DOC17/512774-01; EF16/11941

**Mount Pleasant Coal Mine Modification (DA92/97 MOD3)
Comment on Response to Submissions**

Thank you for your email of 13 October 2017 seeking input and comment from the Environment Protection Authority (“EPA”) on Response to Submissions document from MACH Energy titled ‘*Mount Pleasant Operation Mine Optimisation Modification*’ (“RTS”).

Figure 8

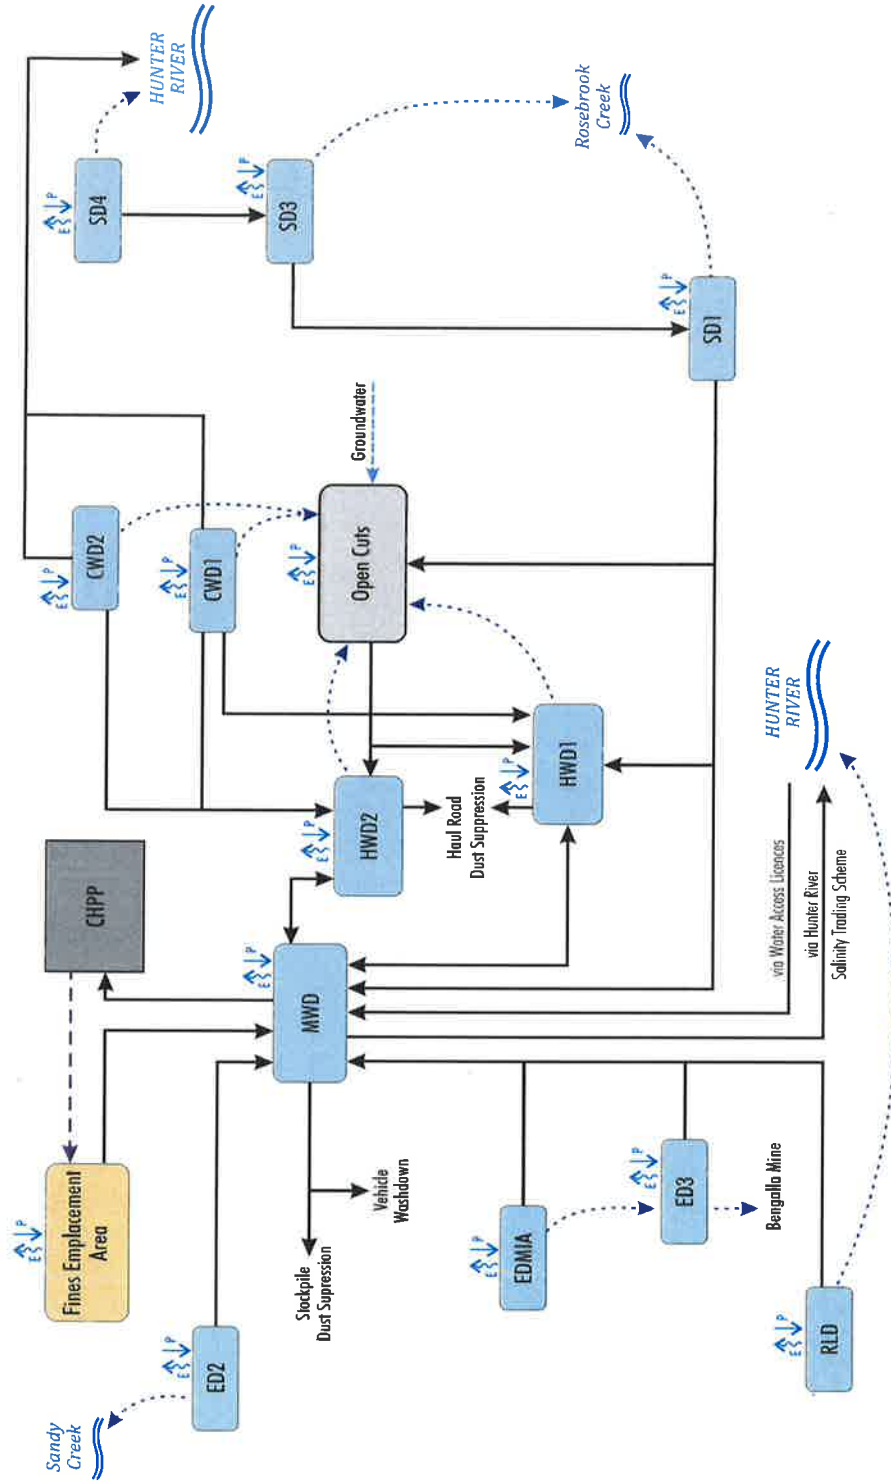
The EPA understands that the discrepancies between the water management system schematics related to the Site Water Balance Review indicating additional information to demonstrating ‘gravity flow’ of where water would flow if the dam design criteria is exceeded. The EPA also understands that the Fines emplacement area and the Mine Water Dam have been model with the outcome that ‘*no spills were simulated*’ from these Dams.

The dams in Figure 8 in the main text of ‘*Mount Pleasant Operations – Mine Optimisation Modification – Environmental Assessment*’ dated 31 May 2017 marked as RLD, SD1, SD3, SD4, ED2 and ED3 all indicate discharges to waterways. In the EPA’s letter of 24 July 2017 information was sort on ‘*the frequency, volume and expected quality of water to be discharged to the environment, as well as the expected quality and quantity of water in the receiving environment during discharge events*’.

Insufficient information has been supplied to enable the EPA to licence any discharges from the premises. The proponent should be advised that in the event of a discharge it must meet, section 120 of the *Protection of the Environment Operations Act 1997* 'pollution of water' including the prescribed matter for the definition of water pollution at schedule 5 of the *Protection of the Environment Operations (General) Regulation 2009*. Any failure to meet these may result in regulatory action.
